<b>Application Ref:</b>	3/2021/0573	 Ribble Valley Borough Council <a href="http://www.ribblevalley.gov.uk">www.ribblevalley.gov.uk</a>
<b>Date Inspected:</b>	29/06/2021	
<b>Officer:</b>	RB	
<b>DELEGATED ITEM FILE REPORT:</b>		<b>REFUSAL</b>

<b>Development Description:</b>	Two Storey rear extension and detached garage
<b>Site Address/Location:</b>	38 Mitton Road, Whalley, BB7 9RX

Drawing Title
PROPOSED PLANS AND ELEVATIONS

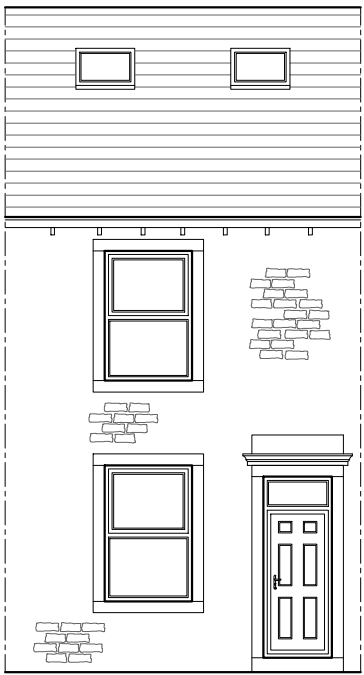
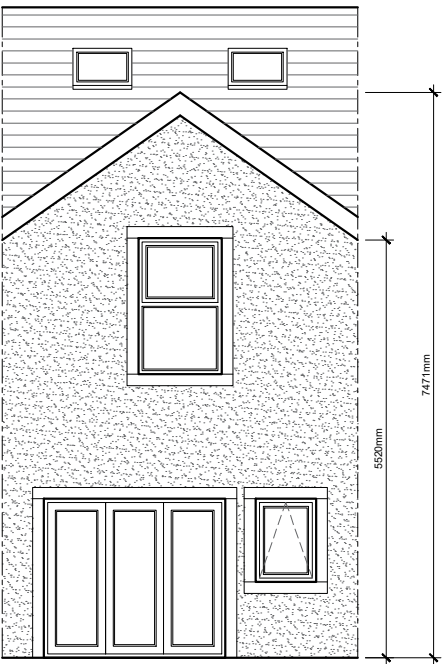
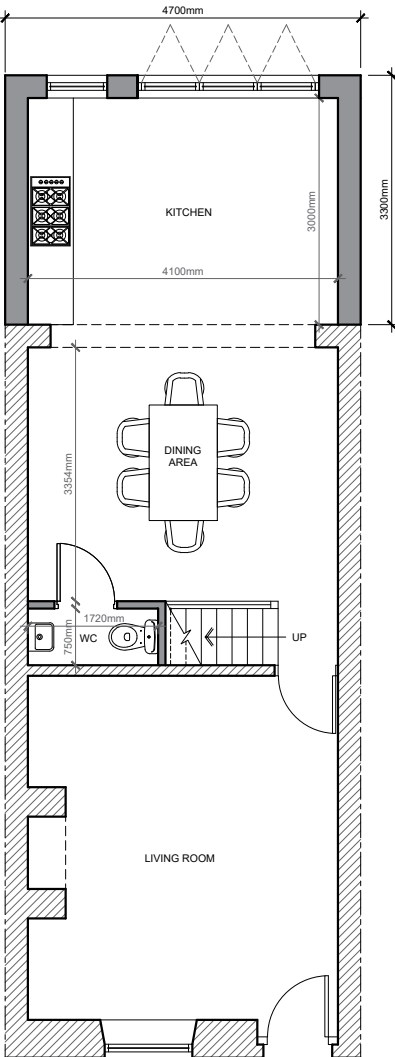
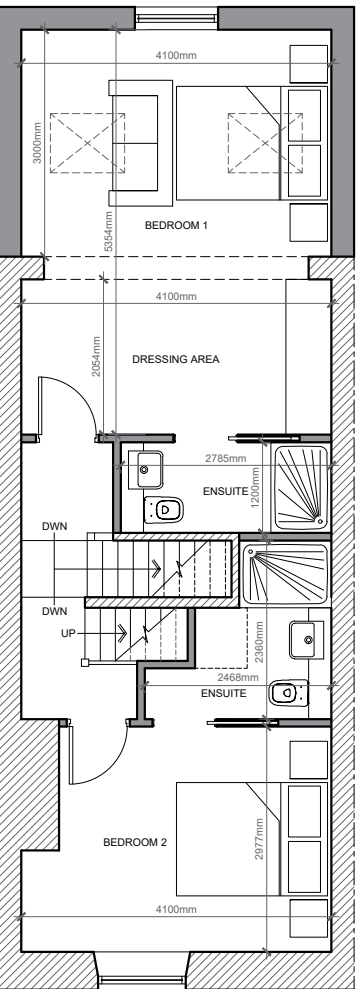
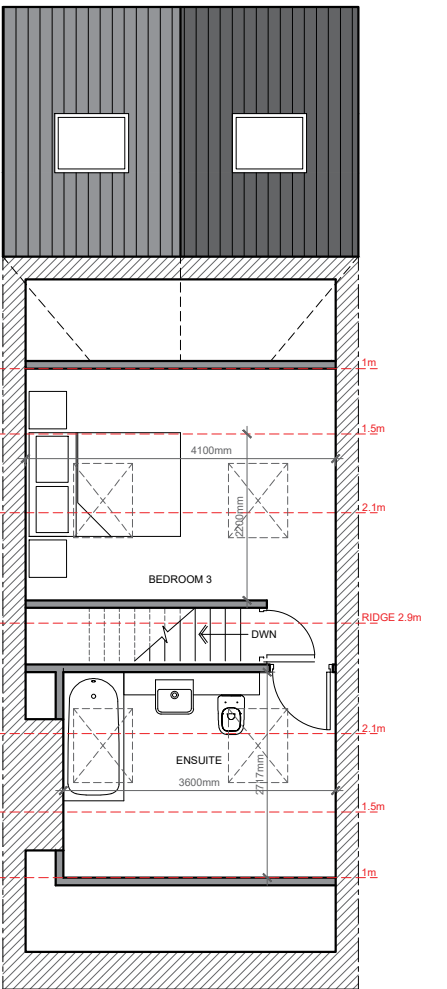
The proposed extension will extend beyond the rear wall of the neighbour, no 36 Mitton Road by 3.3m at ground and first floor. This neighbour benefits from an existing single extension to the rear that has a similar rearward projection to the proposed development, but the extension does not extend the full width of the house and a ground floor window on the rear elevation would be between the side wall of the two storey extension and the sidewall of the neighbours single storey extension. A single window and door also serve this single storey extension and both openings would face the side wall of the two storey extension. As such the proposed extension would create a tunnelling effect to the ground floor of this neighbour causing an unacceptable loss of light and overbearing impact. At first floor there is a single window that serves a bedroom. When assessed against the 45-degree rule there would also be a detrimental loss of light to this window.

As such it is considered that the proposed two storey rear extension would by virtue of its scale, design, mass and proximity to the neighbouring property 38 Mitton Road result in a development that would have an overbearing impact resulting in overshadowing and the loss of natural light to habitable room windows.

The proposed extension will have a rearward projection of 3.3 metres measuring the full width of the dwelling. The ridge of the extension is set significantly below the ridge of the main house which helps to ensure the extension remains subservient to the main house. Furthermore, when compared to the attached neighbours extension the proposed extension would be of a similar if not less scale to the neighbour therefore the proposed extension would not dominate the rear elevation.

The proposed development would by virtue of its scale, massing and proximity to the neighbouring property 38 Mitton Road would result in a development that would have an overbearing impact resulting in overshadowing and loss of natural light to habitable room windows. This would be detrimental to the residential amenity of the adjoining property and its occupants and would be contrary to Policy DMG1 of the Ribble Valley Core Strategy.
